Response to Submissions Report

Prince of Wales Hospital - Addition to approved Acute Services Building (SSD-10339)

NSW Health Infrastructure

1 November 2019

Hospital Road Planting Plan 1:200 @A3

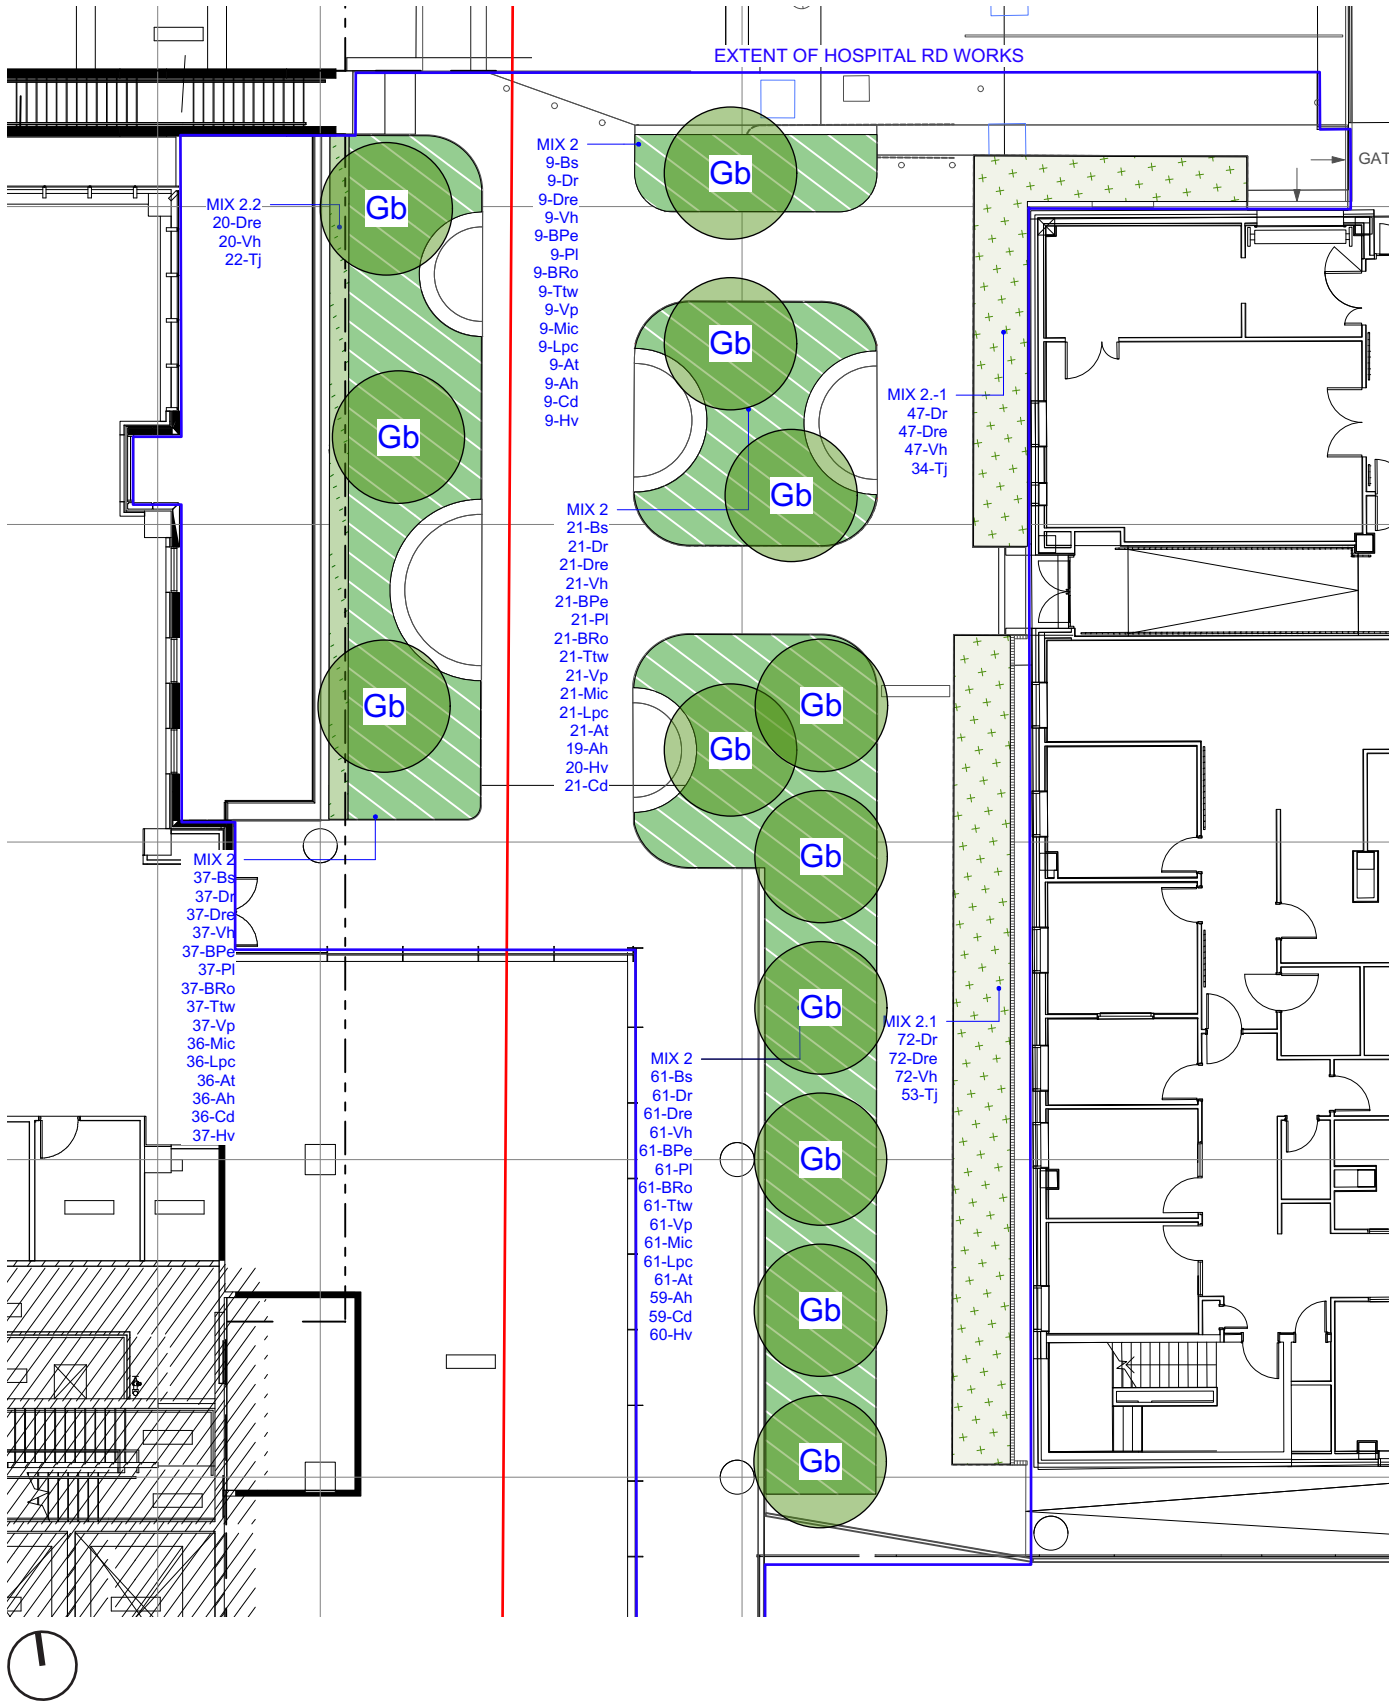
Submission	Response
Randwick City Council	
<p>Landscaping</p> <p>Council notes the Landscape Design Report prepared by ASPECT Studios at Appendix E. As planting incorporating feature canopy trees has been shown at the Level 00 primary pedestrian connection from the north, further details must be provided to confirm that both sufficient soil depth and volume will be provided to sustain the trees for their life term. Further to this, Council requests that the Landscape Design Report is amended to include the following information:</p> <ul style="list-style-type: none"> A planting plan and plant schedule that includes proposed species, botanic and common names, pot size at time of planting, 	<p>Section 5.0 of the updated Landscape Design Report (Appendix D) provides the following information as requested by Council:</p> <ul style="list-style-type: none"> Soil depths and volumes Planting plan and plant schedule Plant origin percentage schedule Quantity of trees in Hospital Road works <p>The lighting strategy for paths and gardens will be developed as part of the design development process. Wayfinding, surveillance and security considerations will inform this strategy.</p>

Submission	Response
<p>quantity, location, dimensions at maturity and any other details required to fully describe the works;</p> <ul style="list-style-type: none"> • A schedule showing the number (as a percentage of total) the endemic, native and exotic species that will be used in all new planting; • A schedule showing the number of new canopy trees to be planted compared to the number of trees to be removed; • Lighting strategy for paths and gardens to assist with wayfinding and surveillance/security. 	
<p>Council raises concern about the cumulative loss of trees on the campus site. The proposal requires 7 native trees and 3 native trees to be removed. It is noted that Health Infrastructure is committed to planting trees on the campus as part of the overall Randwick Campus Redevelopment Project, however Council reiterates that there must be no net loss of tree canopy within the campus.</p>	<p>13 trees will be removed as part of Hospital Road works. 13 new trees are proposed in the new space between the IASB and Ainsworth Building. The updated Landscape Design Report provides further detail.</p>

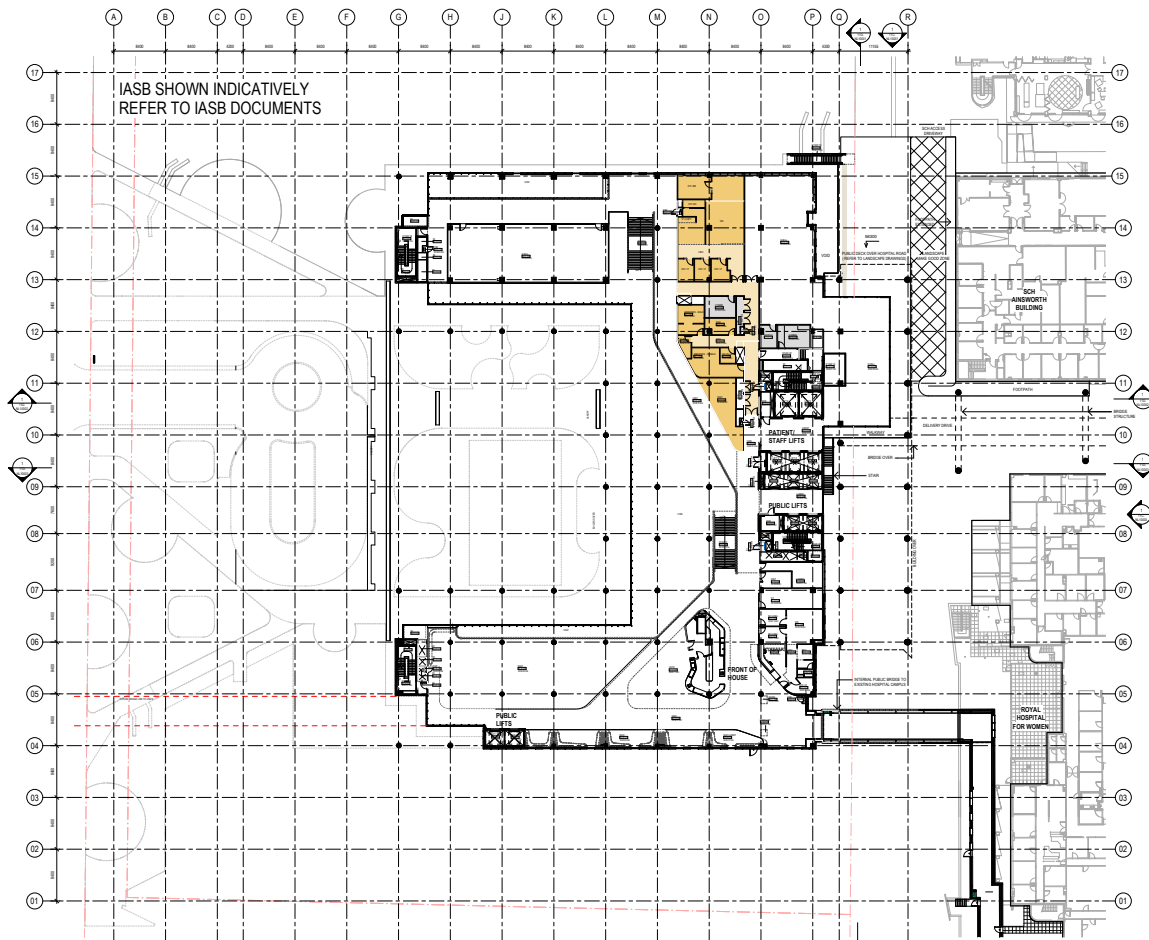
<p>Internal spaces</p> <p>Organise the internal spaces on Level 0 adjacent to the public plaza to activate the public space and provide views into the operations of the building.</p>	<p>Spaces within the IASB Addition footprint located on the Level 00 public deck will be developed as part of future fit-out works. It is envisaged that this area will provide an entry to the facility, and house public-facing functions supported by an activity-based workspace and meeting rooms. A predominately glazed façade will provide visibility into these areas and activation for the shared forecourt zone to the north. Section 5 of the updated Architectural Design Statement (Appendix A) provides additional detail.</p>
